**OXFORDSHIRE COUNTY COUNCIL'S RESPONSE TO CONSULTATION ON THE
FOLLOWING DEVELOPMENT PROPOSAL**

Application no: 14/00412//F

Proposal: Erection of 26 dwellings comprising 17 private market sale dwellings and 9 affordable dwellings and the provision of a car parking area for 40 vehicles for users of the recreational facilities

Location: Clifton Road, Deddington

Drawing title
Site Layout

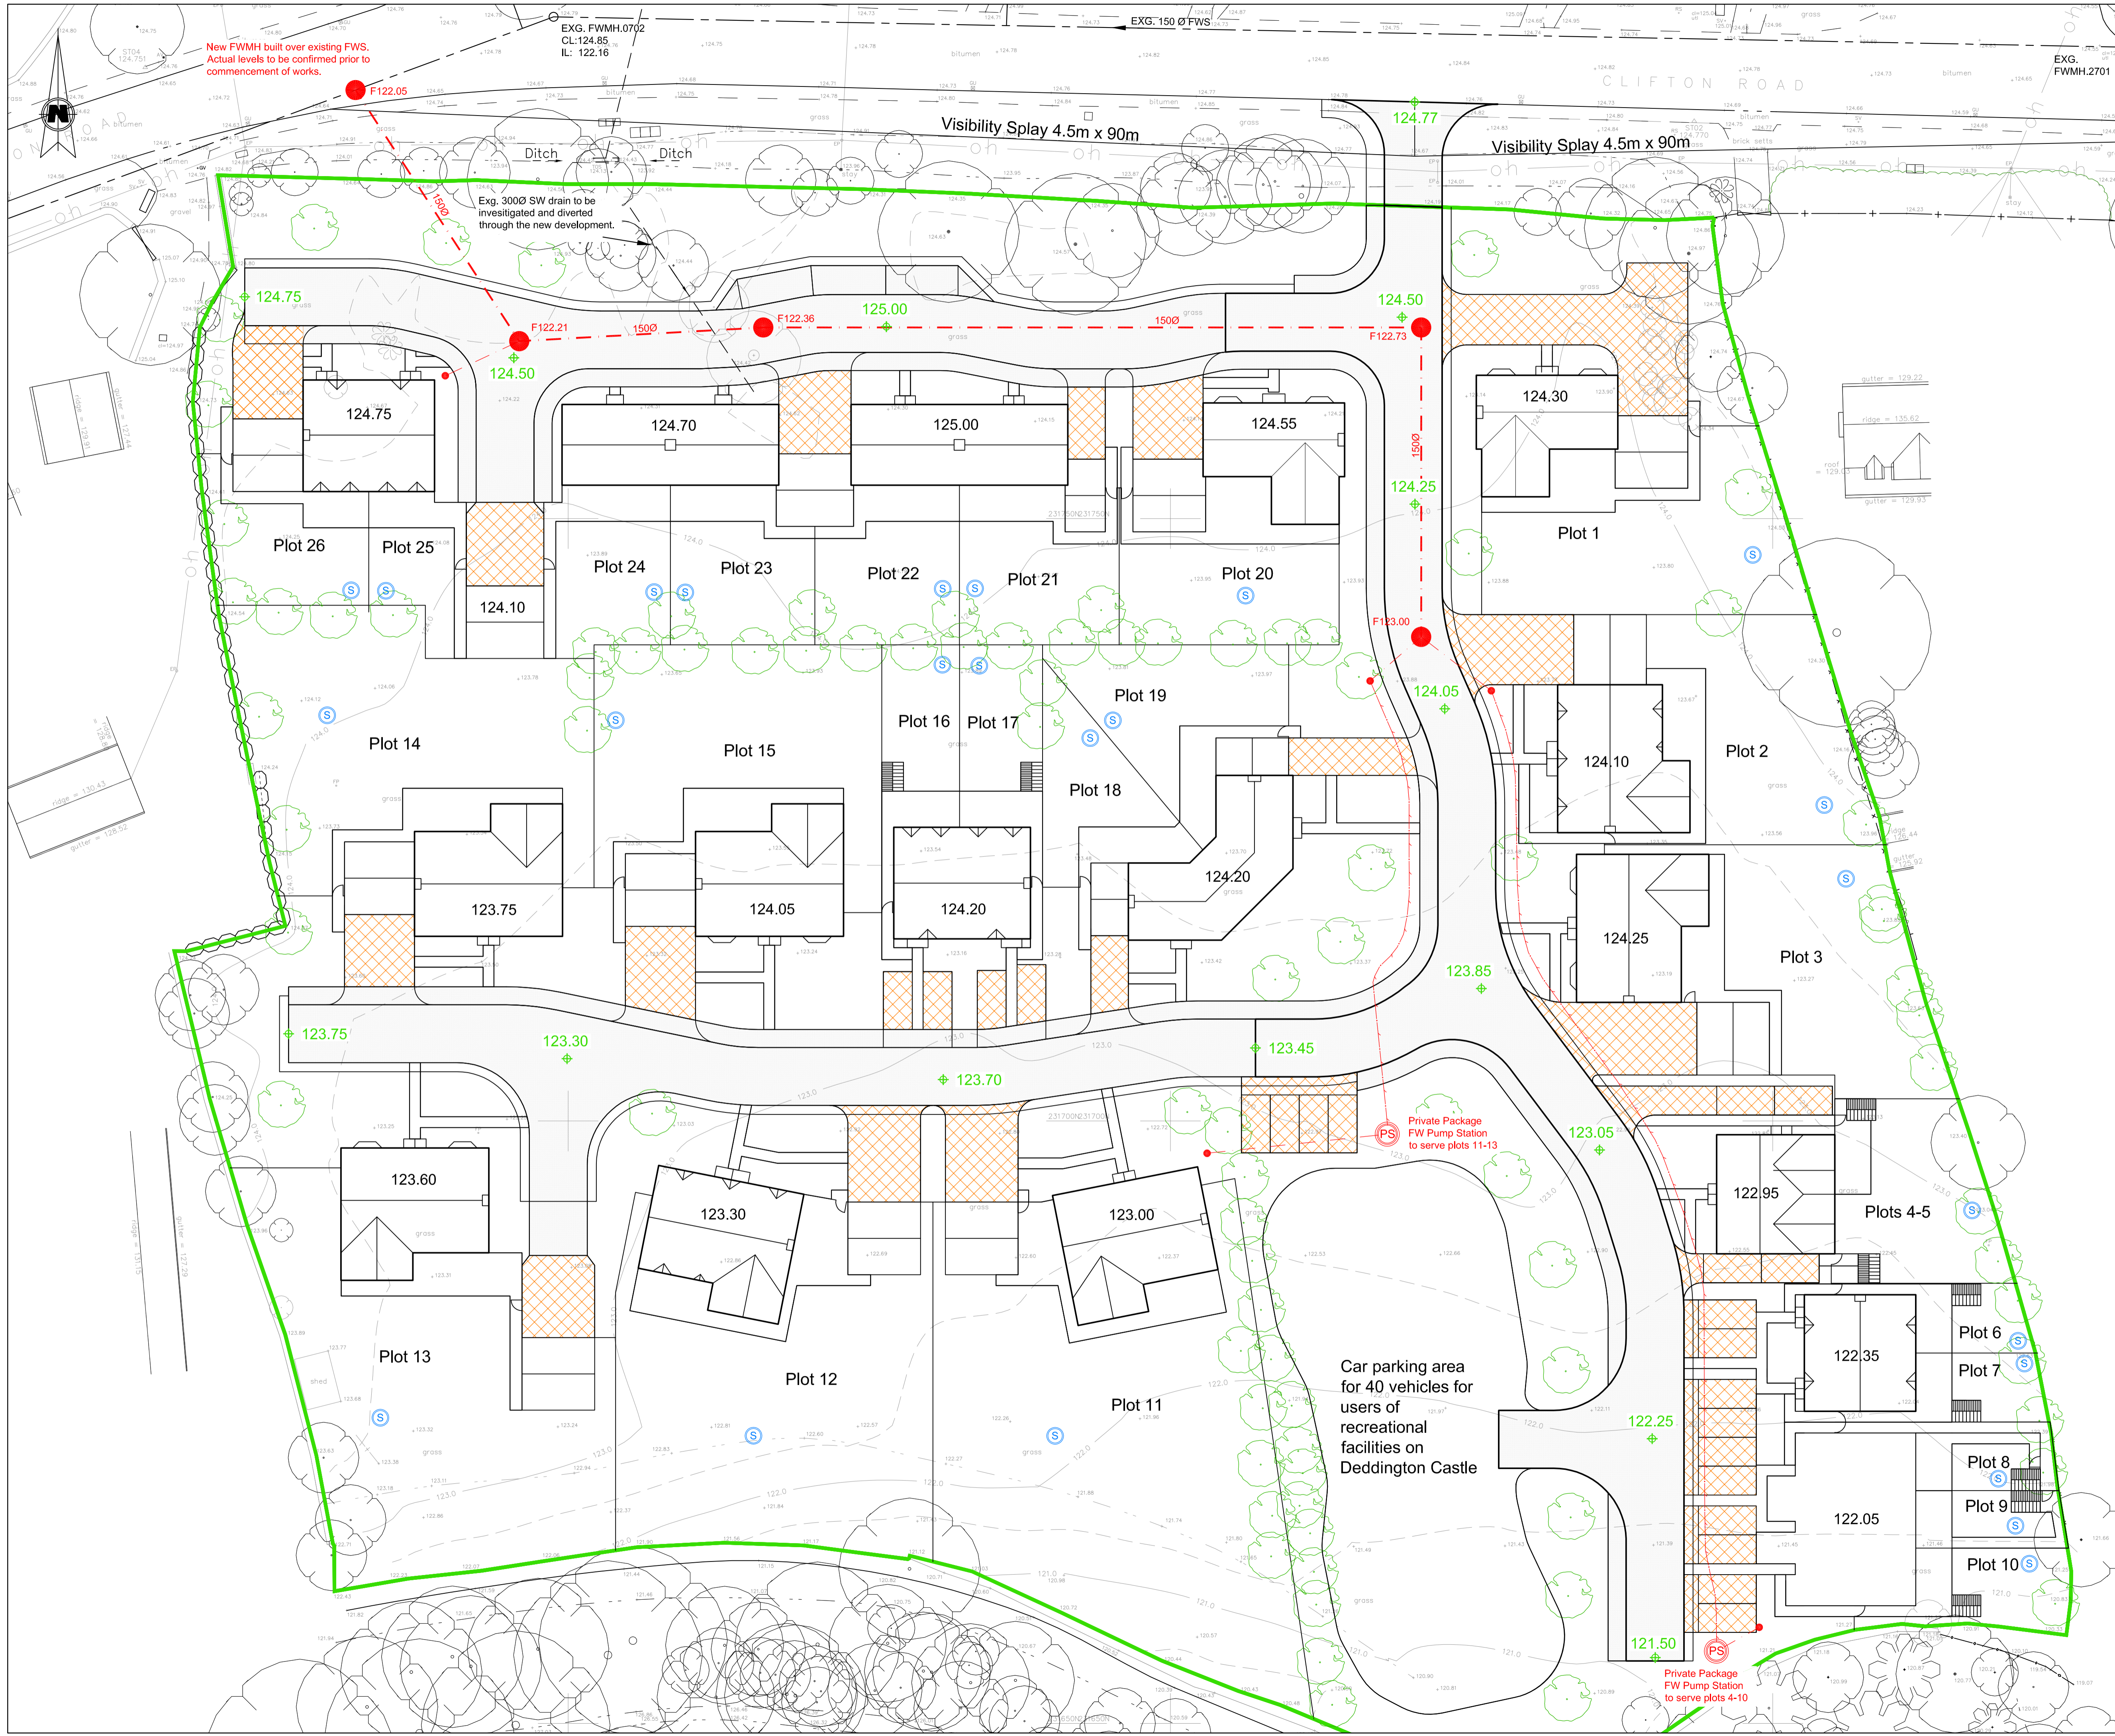
Prior to development, a detailed plan of the access junction with the highway, demonstrating appropriate visibility splays and junction geometry shall be submitted to and approved by the Local Planning Authority. Thereafter the splays shall be provided and retained in accordance with the approved plan.

Prior to development, a plan demonstrating pedestrian visibility splays, at the vehicular accesses to every plot, of no less than 2m x 2m at a height of 0.6m shall be submitted to and approved by the Local Planning Authority. Prior to occupation of any dwelling the splays for that dwelling shall be provided and retained in accordance with the approved plan.

Prior to development a tracking plan demonstrating appropriate turning areas for refuse vehicles shall be submitted to and approved by the Local Planning Authority.

The footway at the North of site shall be improved by widening to a surfaced width of no less than 2m and the provision of an uncontrolled crossing immediately to the West of Earls Lane.

The proposed layout access and parking arrangements are appropriate subject to detailed submissions.
